Rezoning Transportation Analysis

Petition Number: 2023-089

Date	Description
9-28-23	Review (IW)

The petition is located adjacent to Point O'Woods Drive, a City-maintained local street, west of Northlake Centre Parkway, a City-maintained minor arterial. The petition is located in the northlake activity center outside of Route 4, within the I-485 Interchange Analysis Study.

RZ-1.0

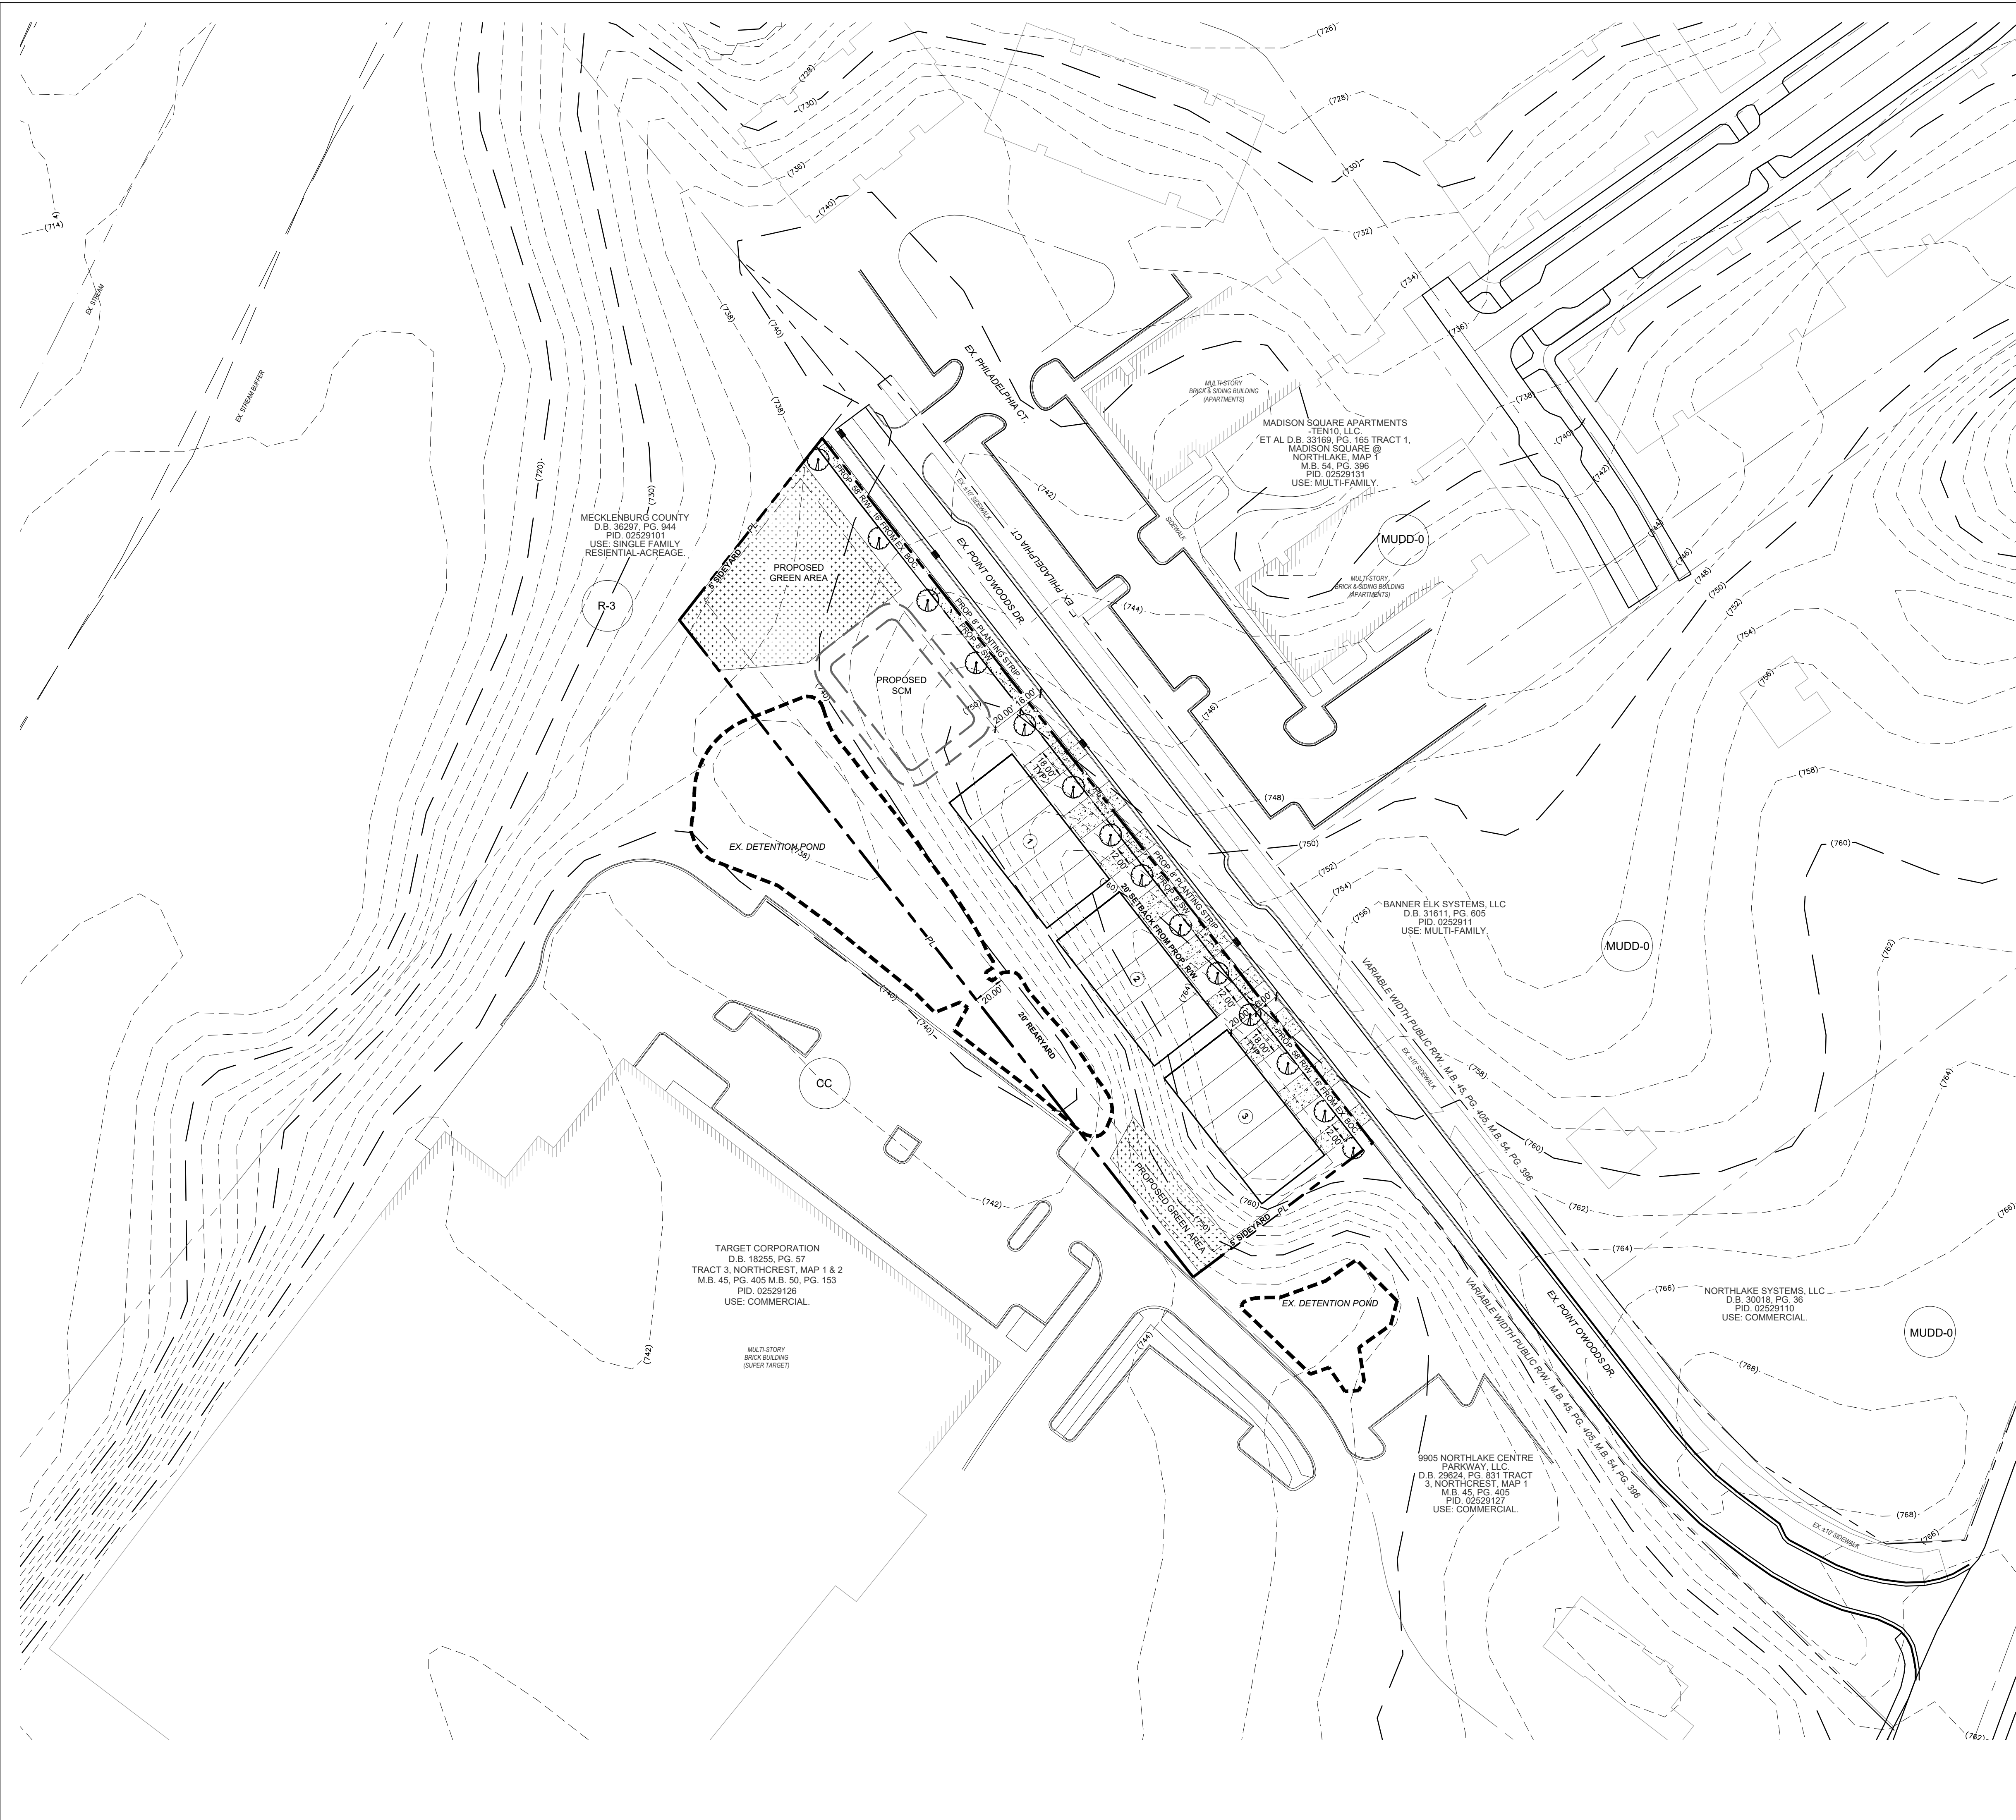
- 6. Revise conditional note 5.d. to commit to an 8' Planting Strip and 8' Sidewalk instead of the 6' Planting strip and 5'sidewalk stated in the note.

RZ-1.0

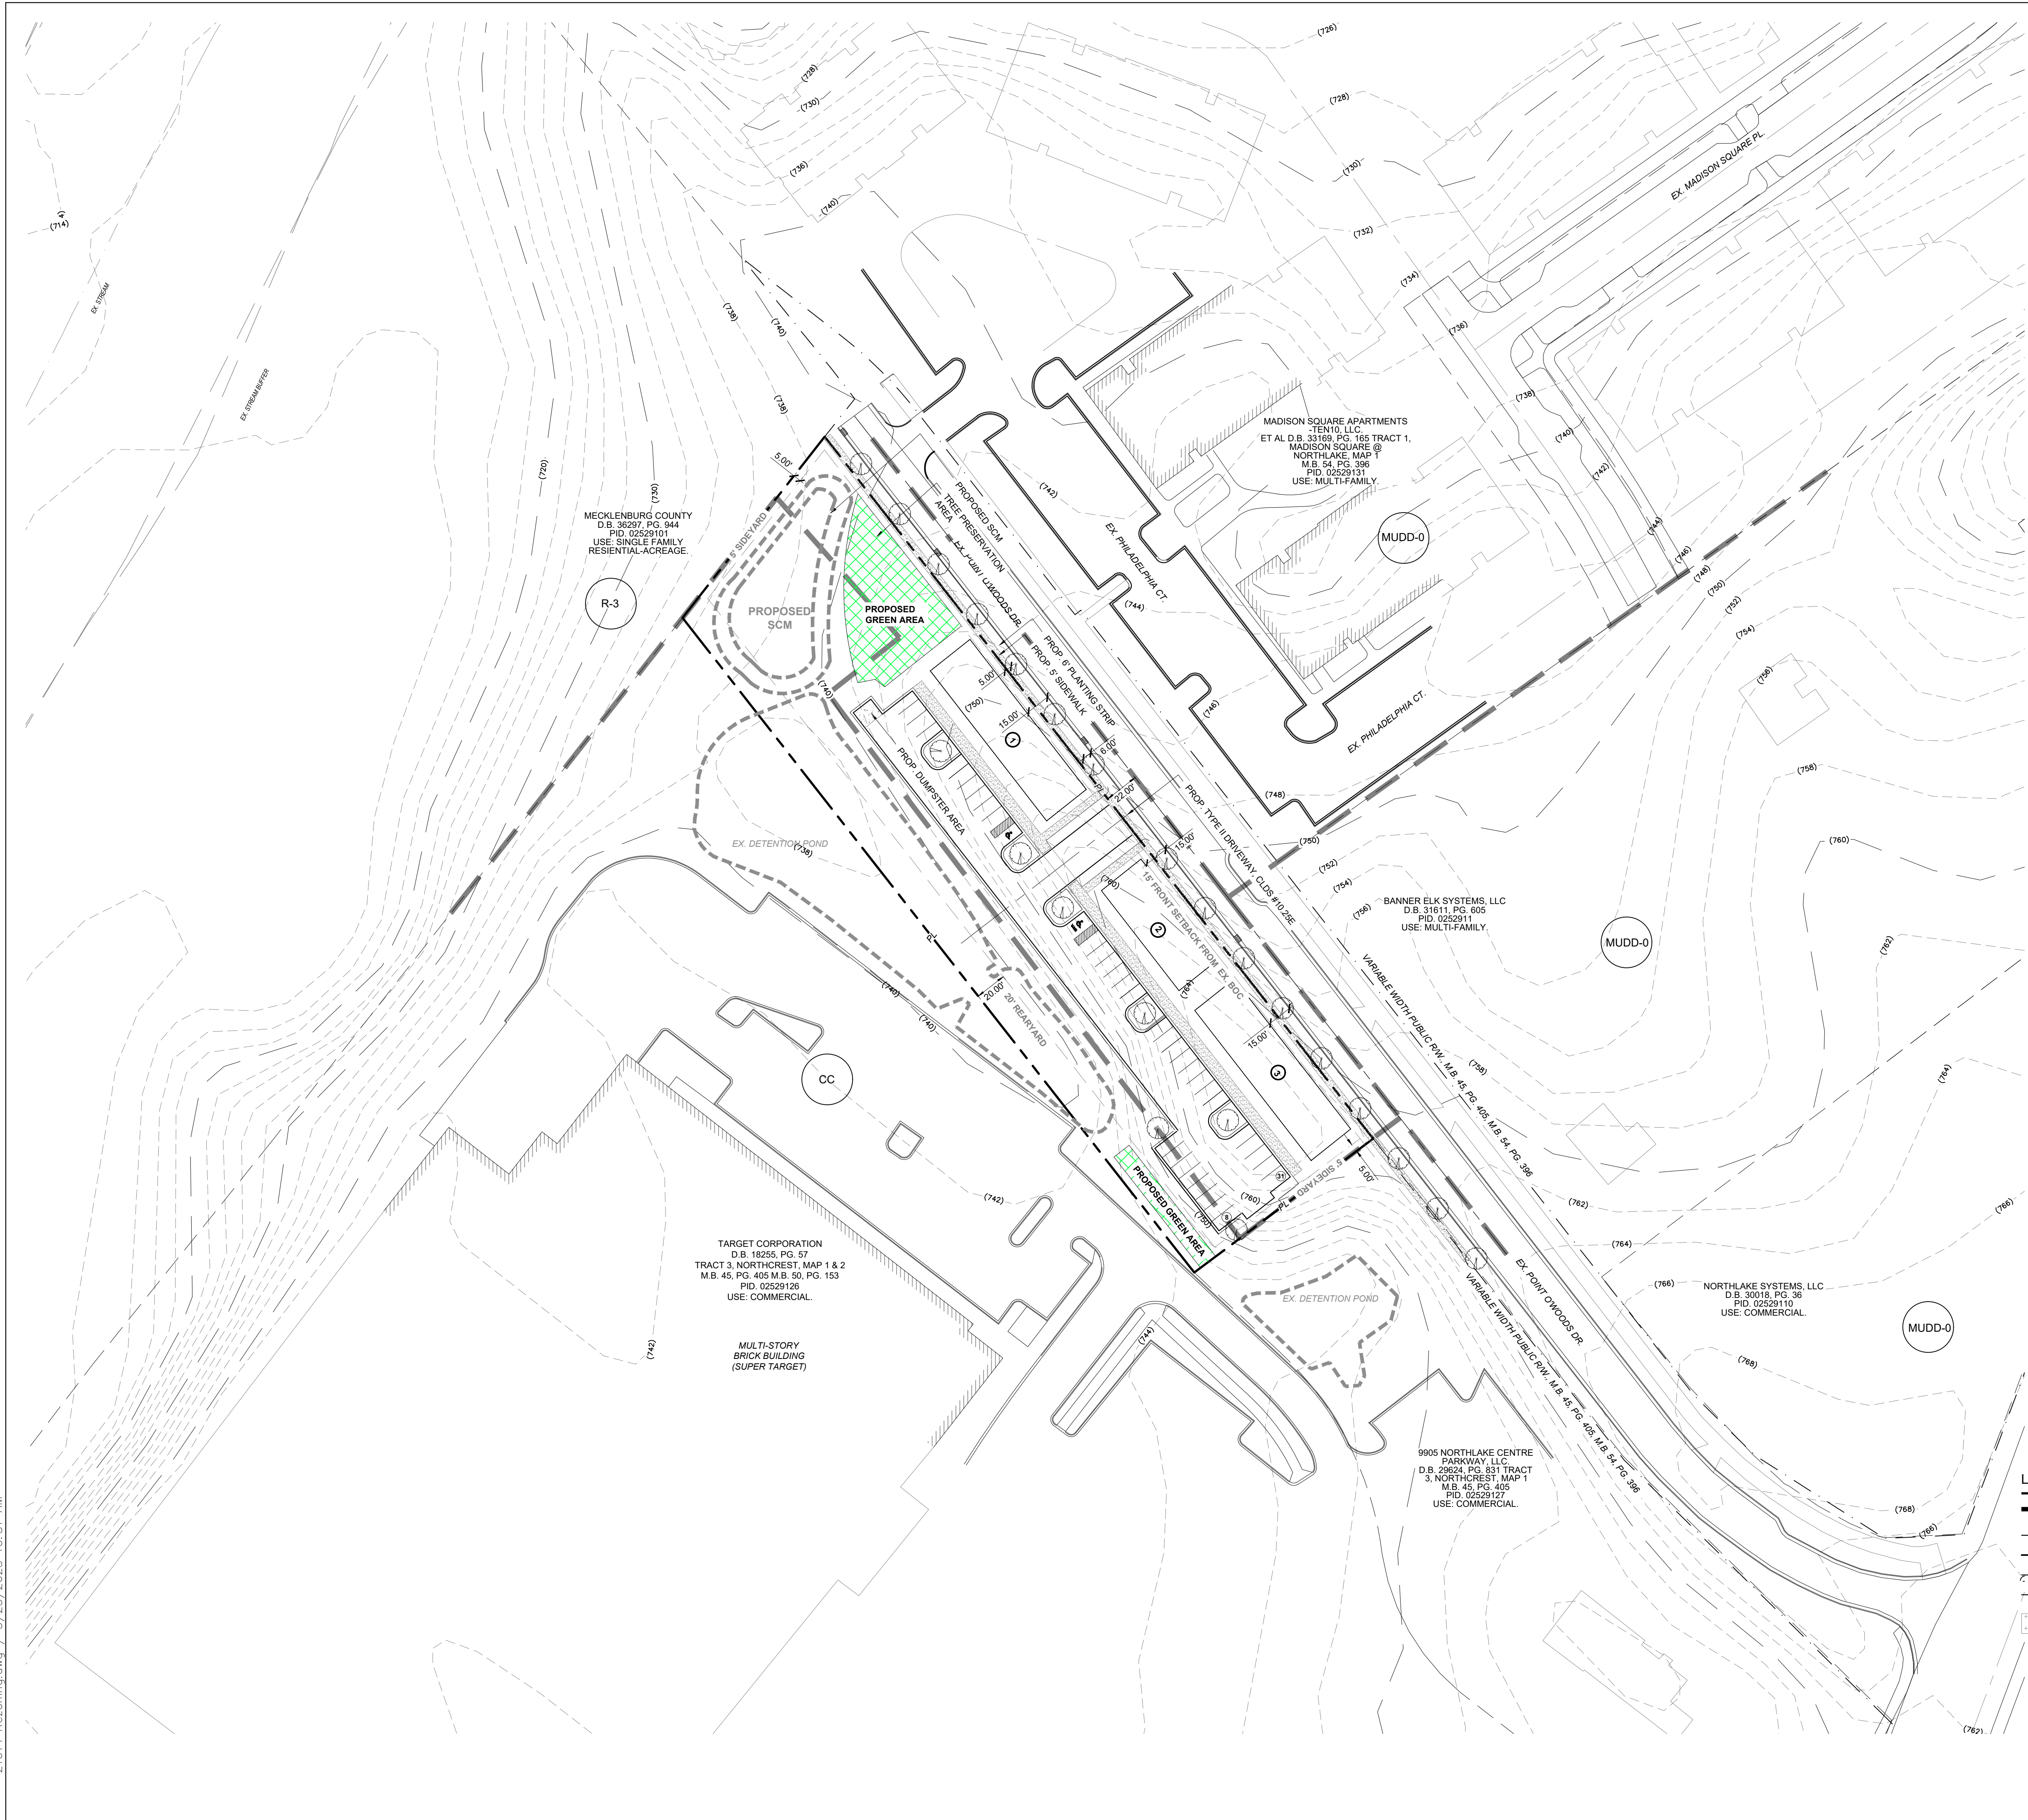
- a. **Point O'Woods Drive:** The future location of curb and gutter is in its existing location.

Label and dimension the curb and gutter from the centerline for each road on the site plan.

- 3. Revise site plan and conditional note(s) to commit to dedicate 27 feet of right-of-way from the road centerline. The site plan shall label and dimension the right-of-way from the road centerline.

- 5. Revise site plan and conditional note(s) to commit to installing an 8' Planting Strip and 8' Sidewalk based on Article 33 in the UDO for Neighborhood 2 Place Type.
